**ASICS Warehouse and Distribution Centre (SSD 9153), 4 Darling Street, Marsden Park
Notice of Exhibition**

Figure 1: Site Plan

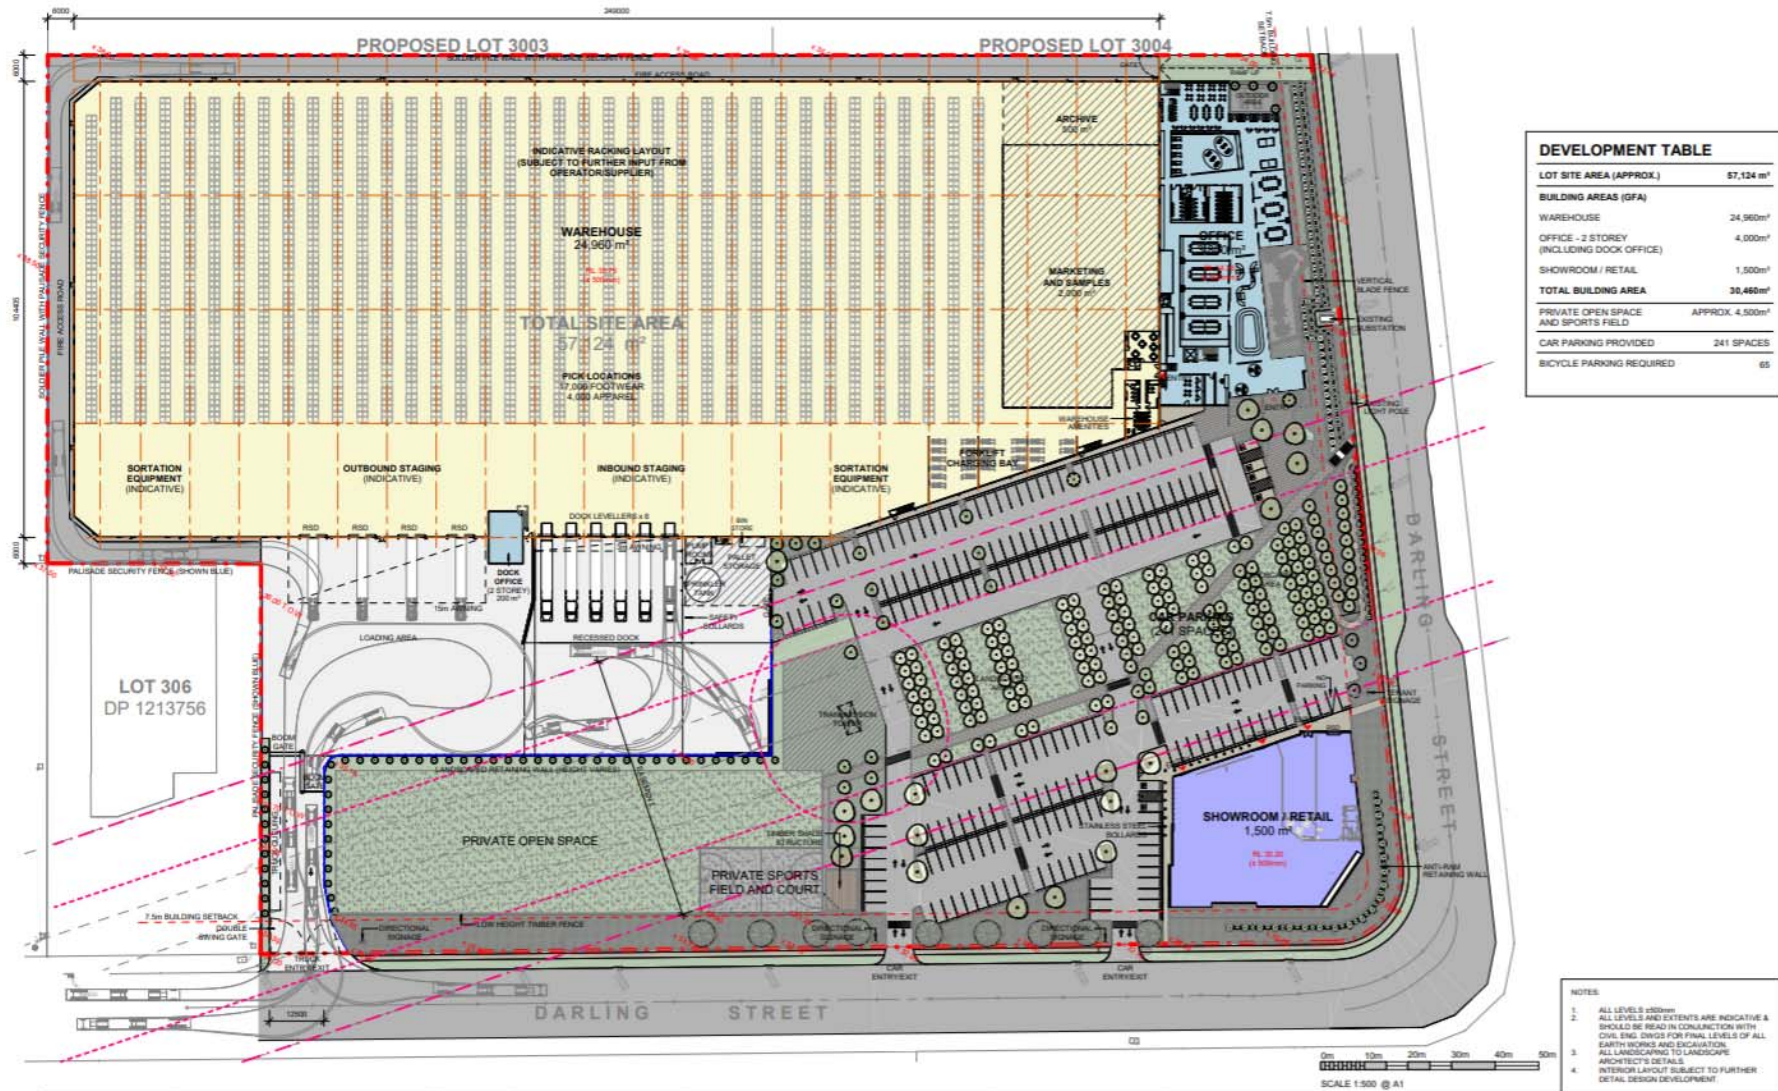
The following comments are provided in relation to loading dock arrangement and turning paths of vehicles:

- The absence of a splay at the western approach to the truck access creates a sharp transition (at the boundary edge) and has the potential to cause conflicts between vehicles entering from the west (left turn in) and the trucks queuing to exit;
- The needs of B-doubles are not addressed inside the facility and the loading dock, including queuing impacts for East bound trucks making a right hand turn into the dock; and

- Expected hours of operation and the hourly profile of vehicle movements accessing the loading dock are not provided.

TfNSW requests that:

- The applicant amend the driveway design for the heavy vehicle access or prepares a loading dock management plan to minimise the conflict between vehicles entering from the west (left turn in) and the trucks queuing to exit;
- Expected hours of operation and the hourly profile of vehicle movements accessing the loading dock be provided; and
- The needs for the facilities associated with B-doubles and higher productivity vehicles be investigated in detail, including queuing impacts on Darling Street.
